Application no: H16-0288-11

Description: Alterations and extensions to existing two-storey dwelling to form two separate apartments

Location: 45 Bourne Road
Spalding
Lincs
PE11 1JN

Amendment: First floor window omitted and elevations renamed
(dwg. no. 10/261/PA/002C)

Drawing Number:
10/261/PA/002

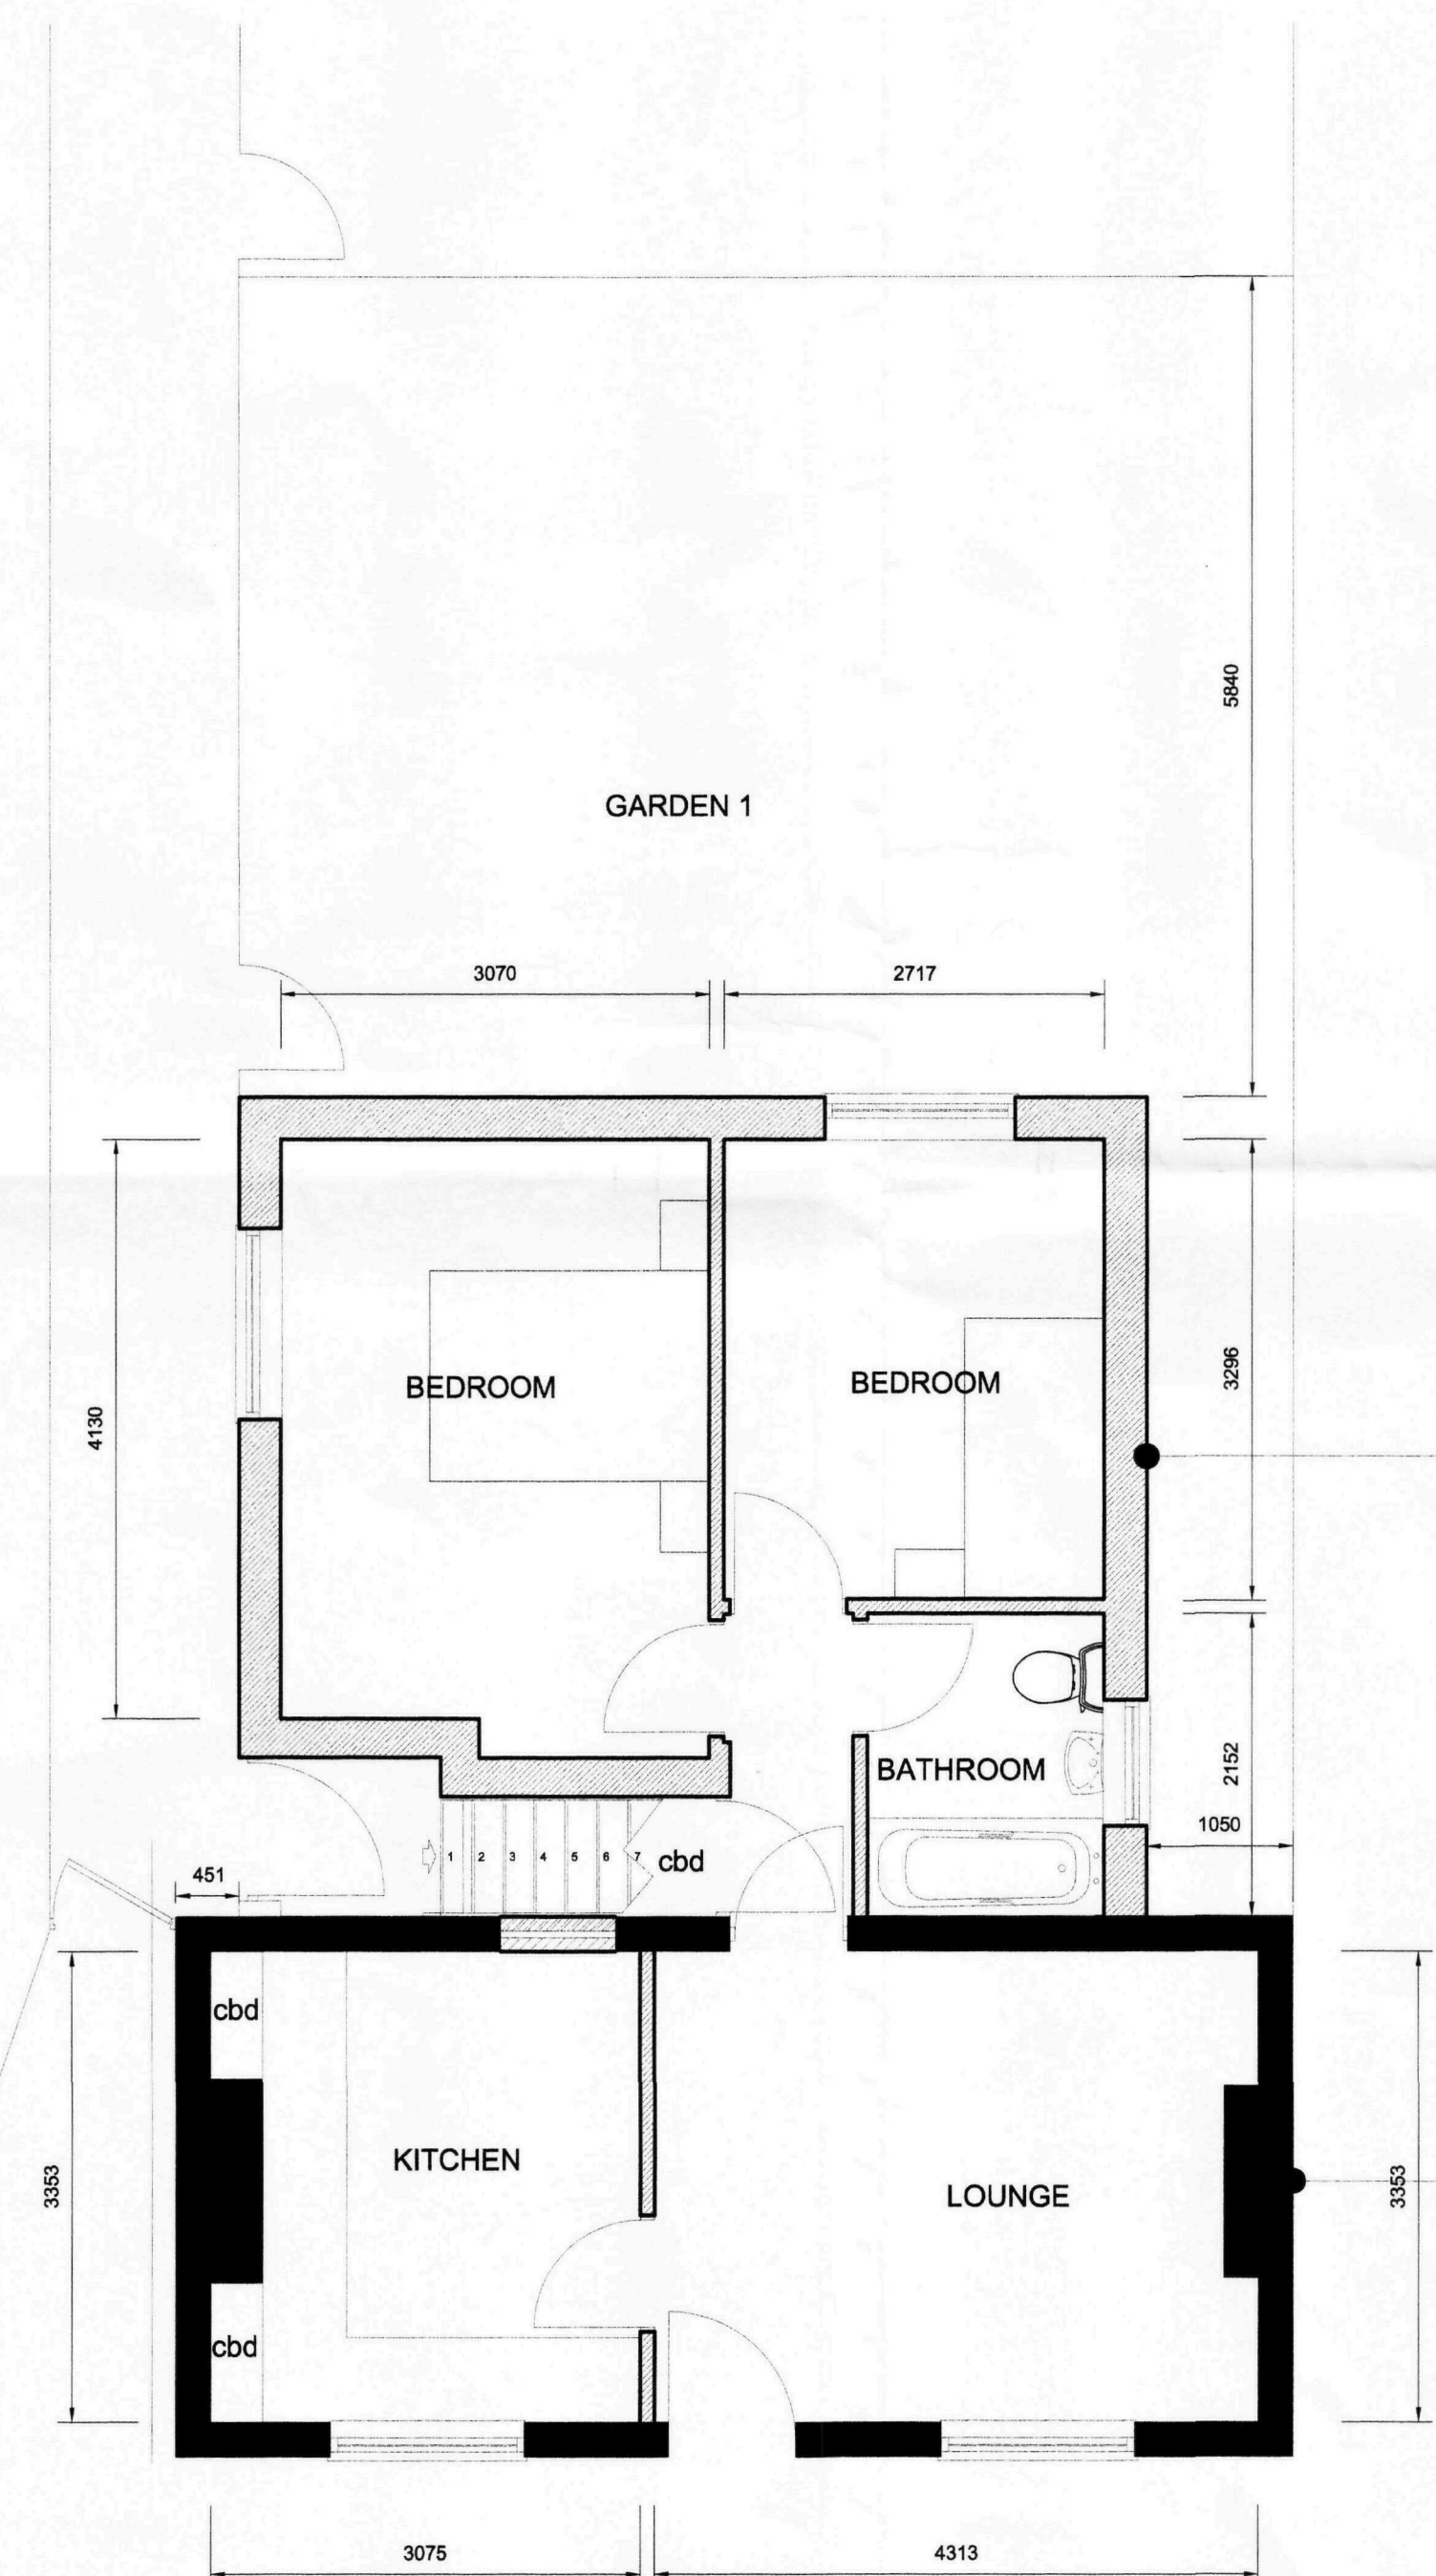
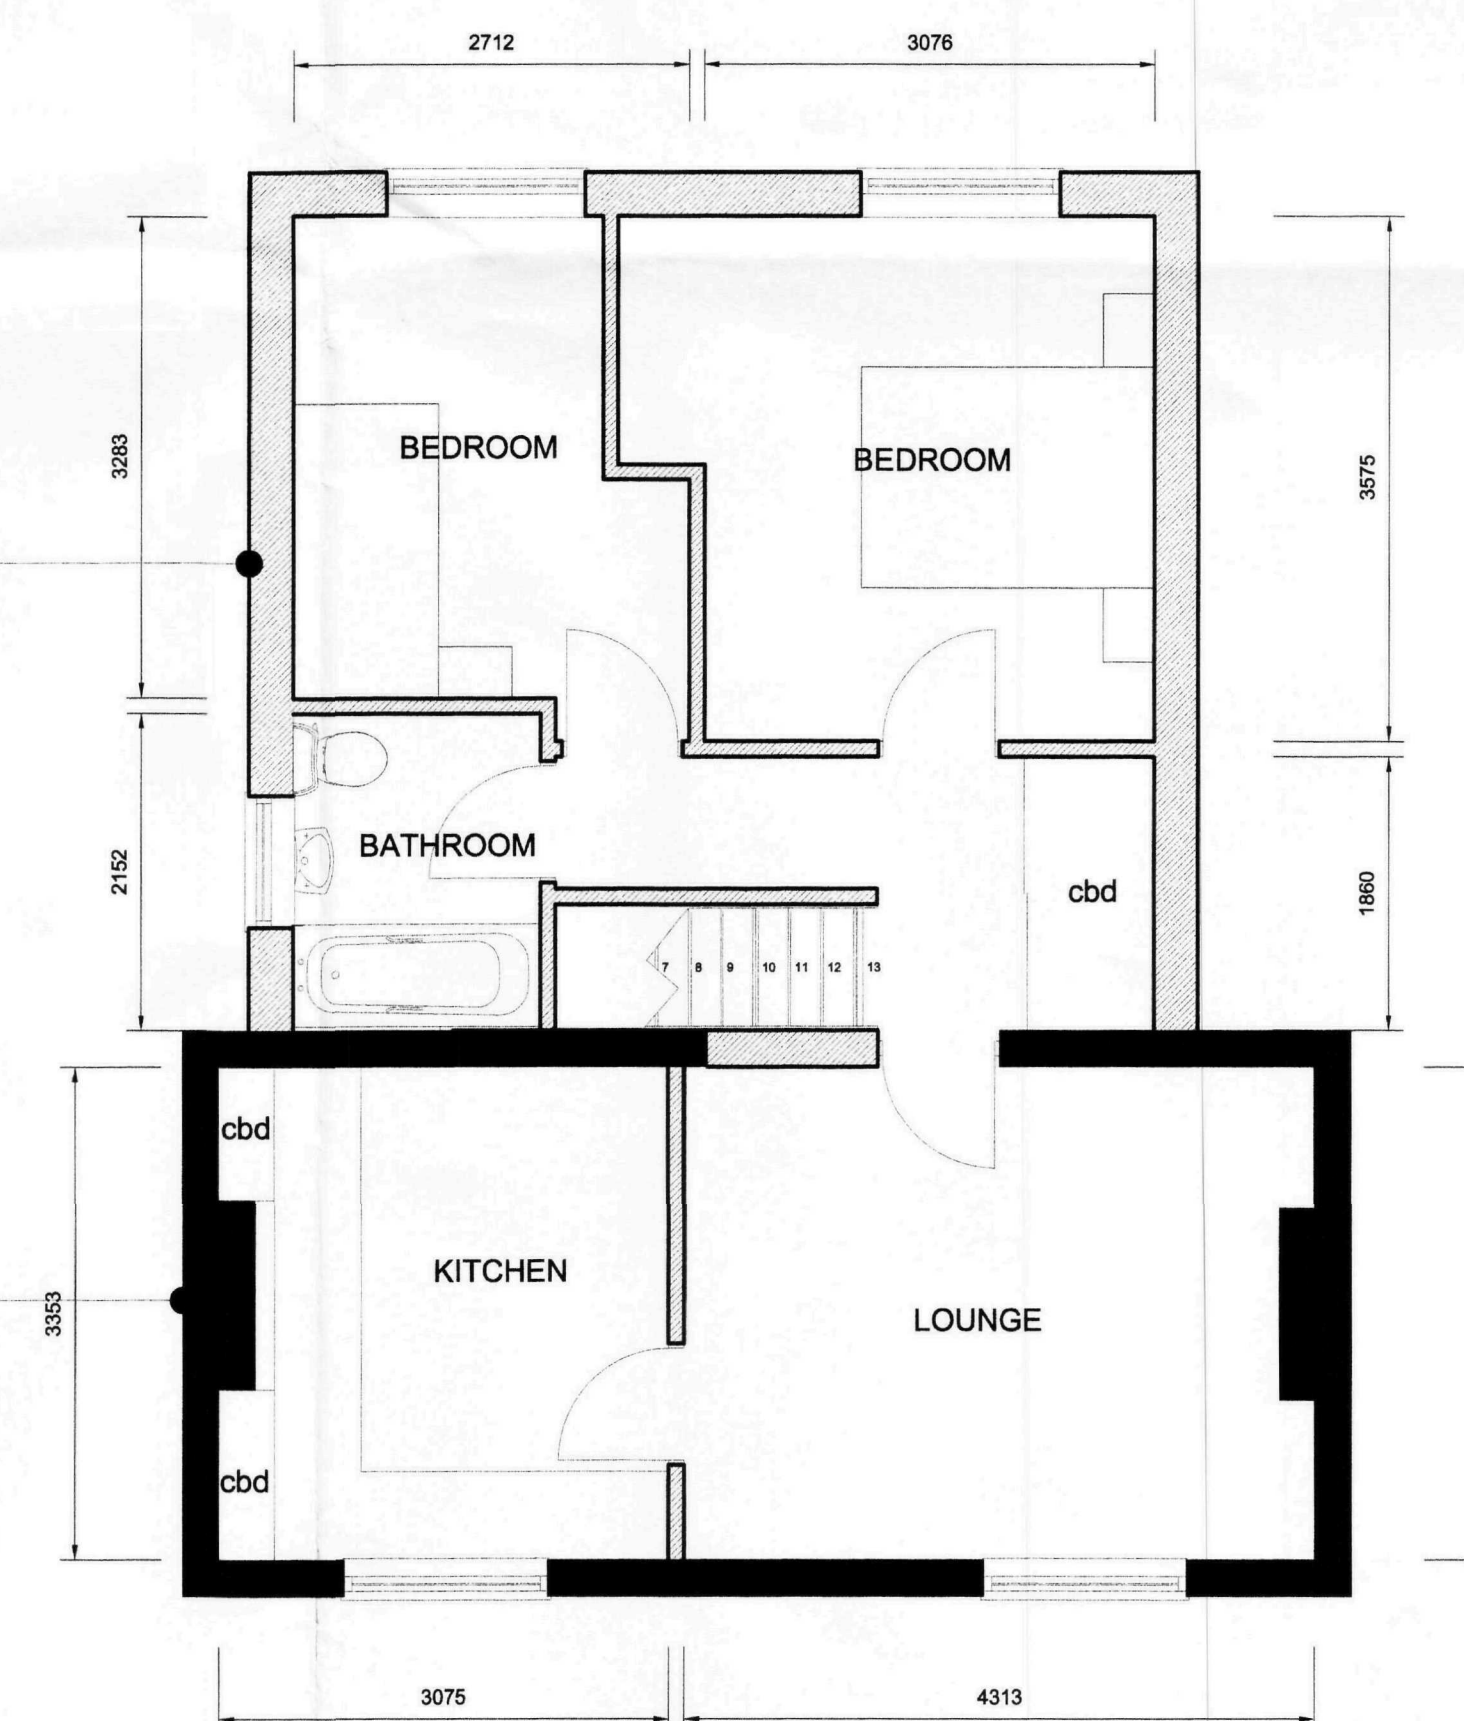
I have corrected the Bourne Road window anomaly, and have also noticed that the geographical orientation was wrongly labelled on the elevations. I can revise the drawing number and send you an electronic copy, but will this slow things down?
